# FIVE ESTUARIES OFFSHORE WIND FARM

# 10.63 APPLICANT'S COMMENTS ON DEADLINE 7 SUBMISSIONS

Application Reference: EN010115
Document Number: 10.63
Revision: A

Pursuant to: Deadline 8
Eco-Doc Number: 005748885-01
Date: March 2025

Figure 1: Design Guide Review Process

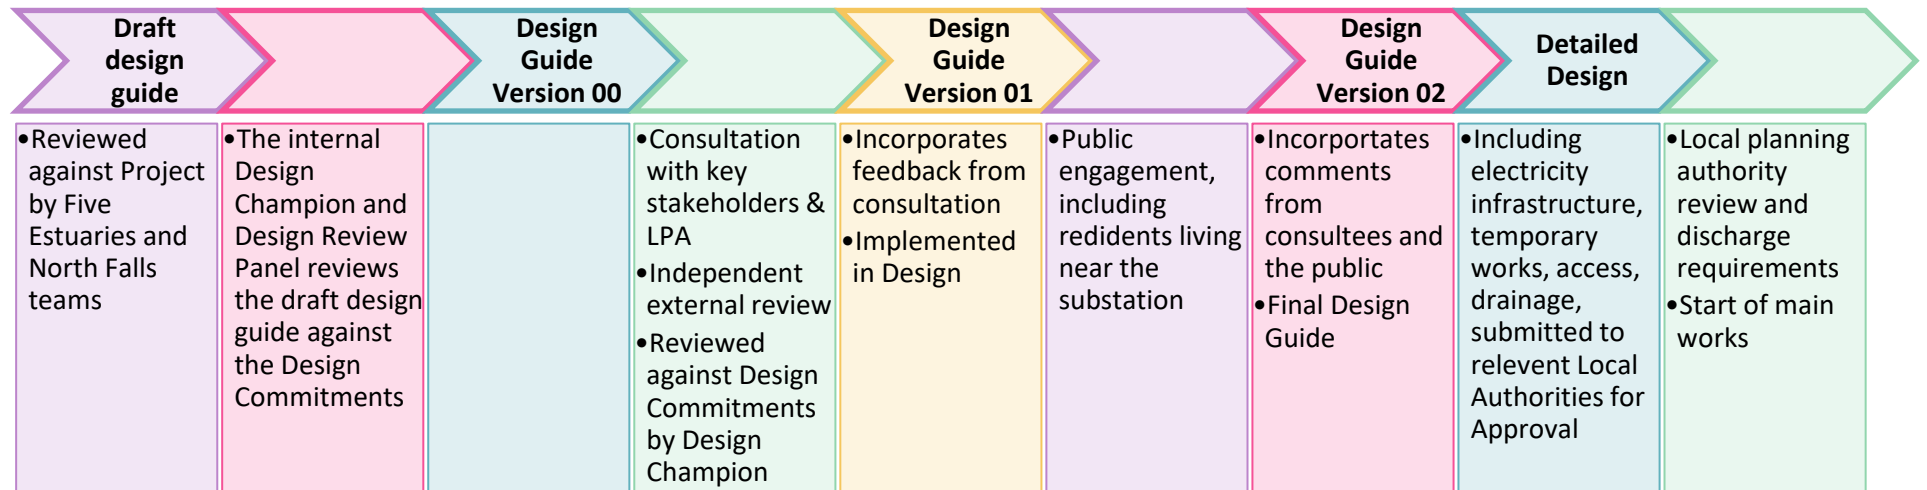
ECC-27	Onshore Substation Design Principles Document (REP6-018) We welcome inclusion of Section 2.4 Independent Advice in relation to the work of the Design Council Design Review Panel. Also, the inclusion of para 4.6.2 in relation to an Environmental Colour Assessment.	This is noted by the Applicant.
ECC-28	In relation to Para 4.6.4, Security Fencing, every opportunity should be taken for security fencing to hug the operational working area as tightly as possible allowing the use of native buffer planting to screen this effectively. Lower timber post and wire fencing, native hedgerows or similar can then be used to mark ownership boundaries if required.	This is noted by the Applicant. The operational fencing needs to comply with the relevant security standards.
ECC-29	Section 4.7: Para 4.7.1 should read 'landscape and ecological mitigation strategy' to emphasise that the landscape planting is not just there for decoration but as an integral part of the LVIA mitigation strategy.	This has been updated in the Revision C of 9.4 Onshore Substation Design Principles Document submitted at Deadline 8.
